# Charlotte Department of Transportation

## Memorandum

**Subject:** Rezoning Petition 08-036: Located south of Old Mt. Holly Road on the southeast end of Aqua Chem Drive

C1.0

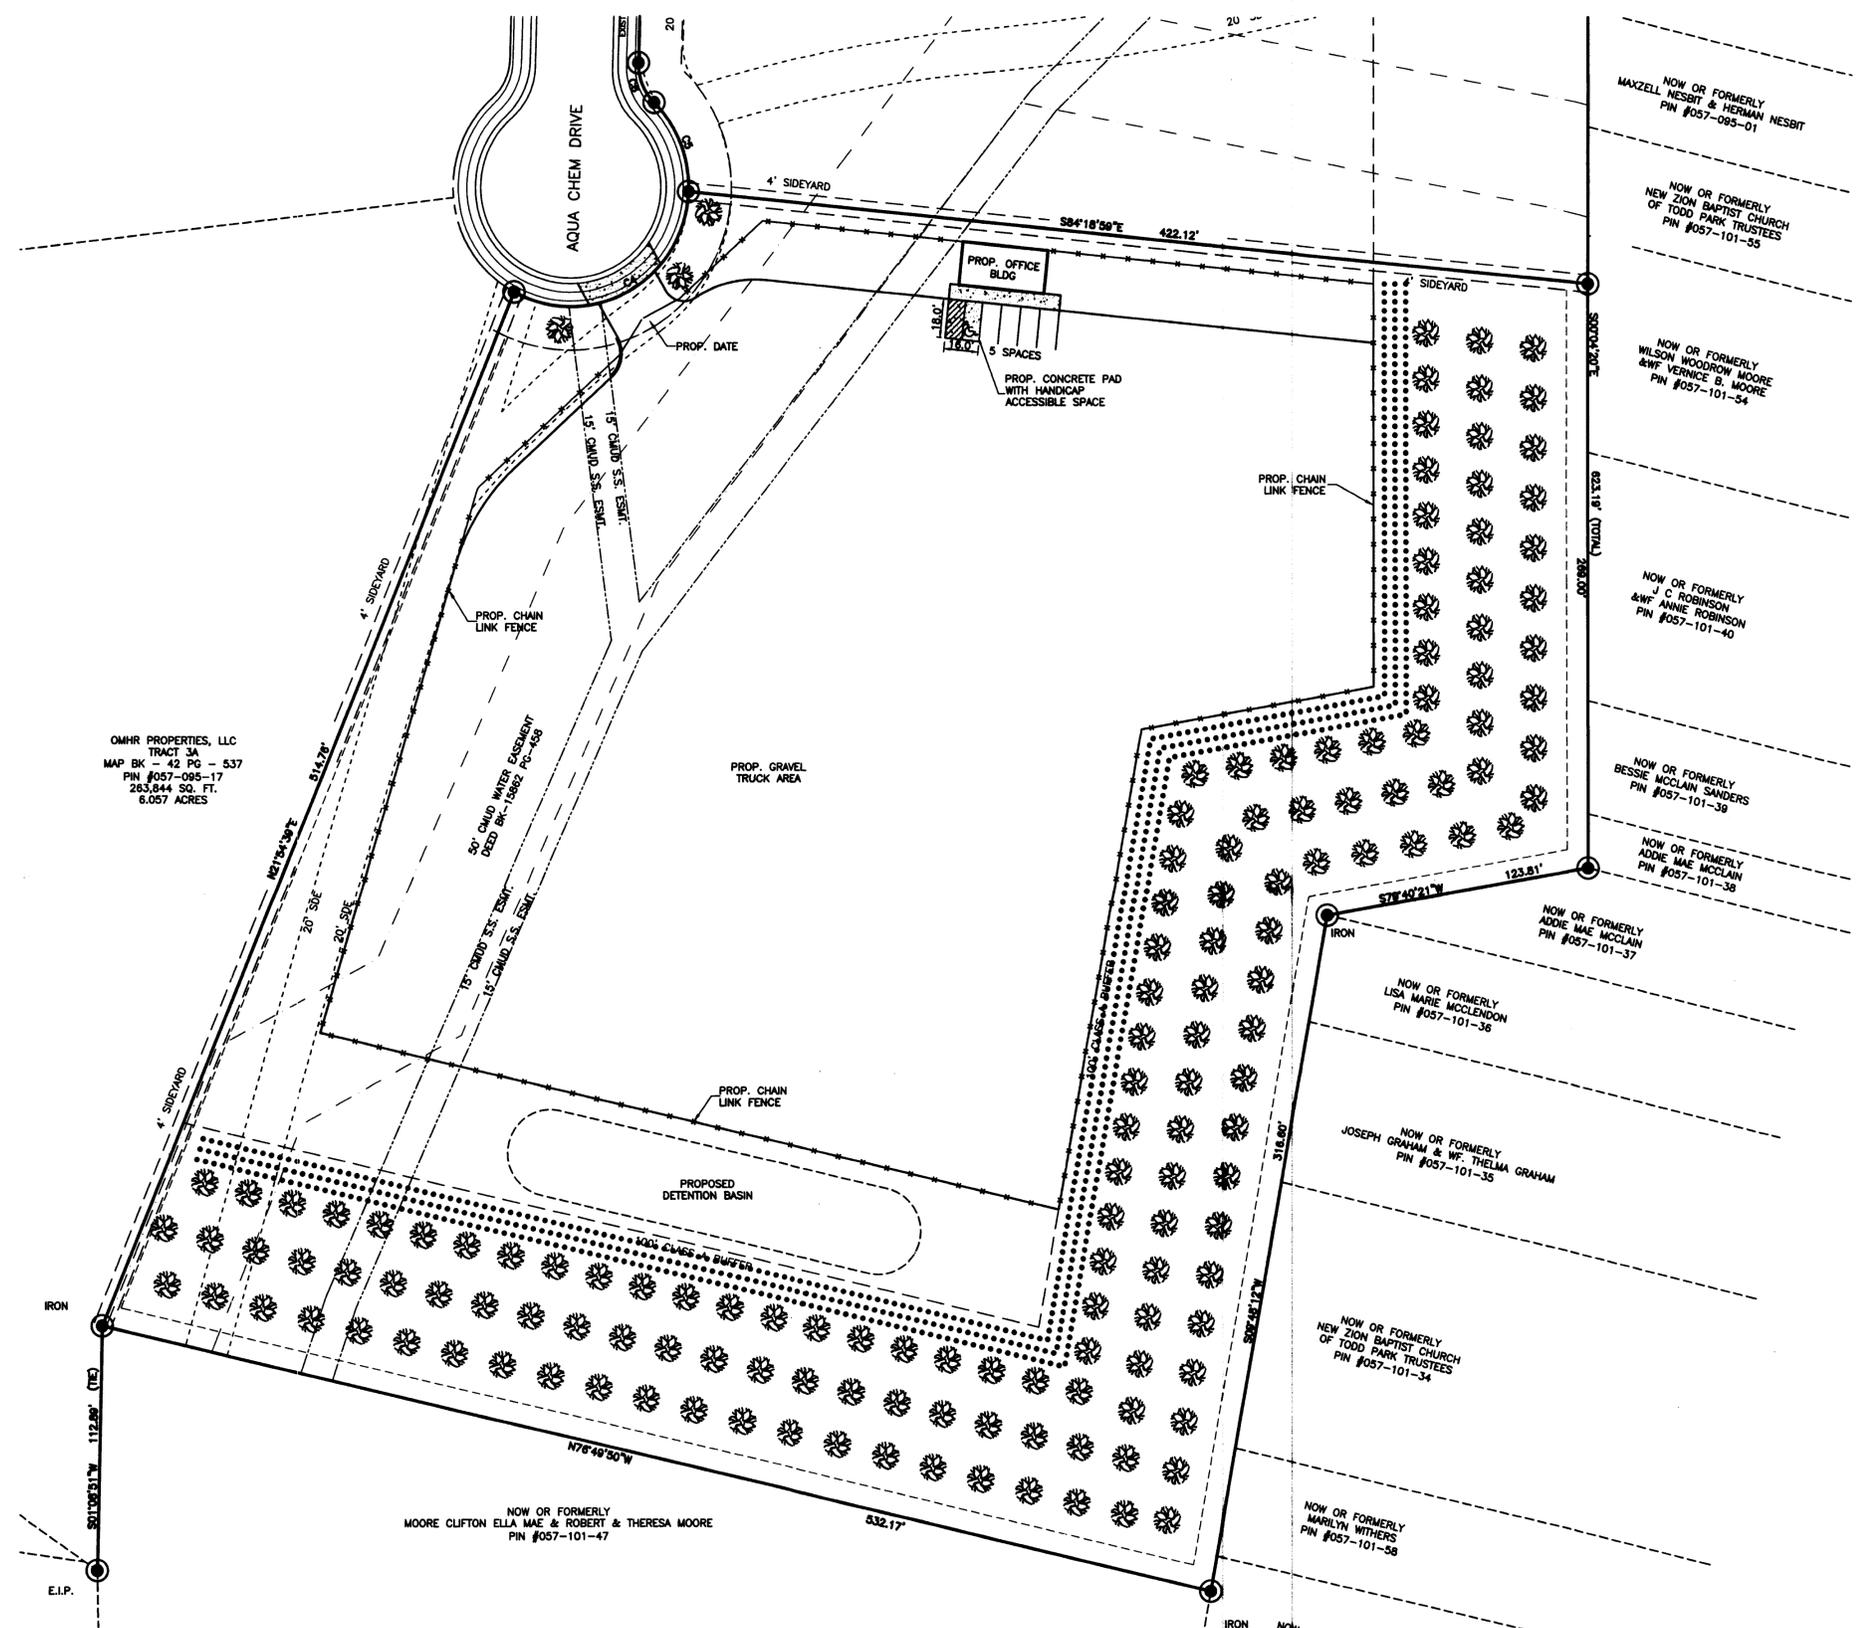
1. The site plan needs to provide an internal system of 5-foot or wider sidewalks that connect building entrances to sidewalks along Aqua Chem Drive.
2. As shown on the site plan, the driveway is proposed to be gated. The gates must open and be recessed into the site a sufficient distance to store an entering vehicle without encroachment into the right-of-way. This distance measured between the gates and the right-of-way is dependent on the length of the truck accessing the site and will be reviewed during the building/driveway permit process.

Adequate sight triangles must be reserved at the existing/proposed street entrance(s). Two 10' x 10' sight triangles behind the sidewalk are required for the entrance(s) to meet requirements. All proposed trees, berms, walls, fences, and/or identification signs must not interfere with sight distance at the entrance(s). Such items should be identified on the site plan.

The proposed driveway connection(s) to Aqua Chem Drive will require a driveway permit(s) to be submitted to CDOT for review and approval. The exact driveway location(s) and type/width of the driveway(s) will be determined by CDOT during the driveway permit process. The locations of the driveway(s) shown on the site plan are subject to change in order to align with driveway(s) on the opposite side of the street and comply with City Driveway Regulations and the City Tree Ordinance.

- Dimension width of the existing and proposed driveways.
- New/reconstructed driveways must be drop curb ramp Type II driveways.
- Indicate the locations and widths of all adjacent and opposing driveways.
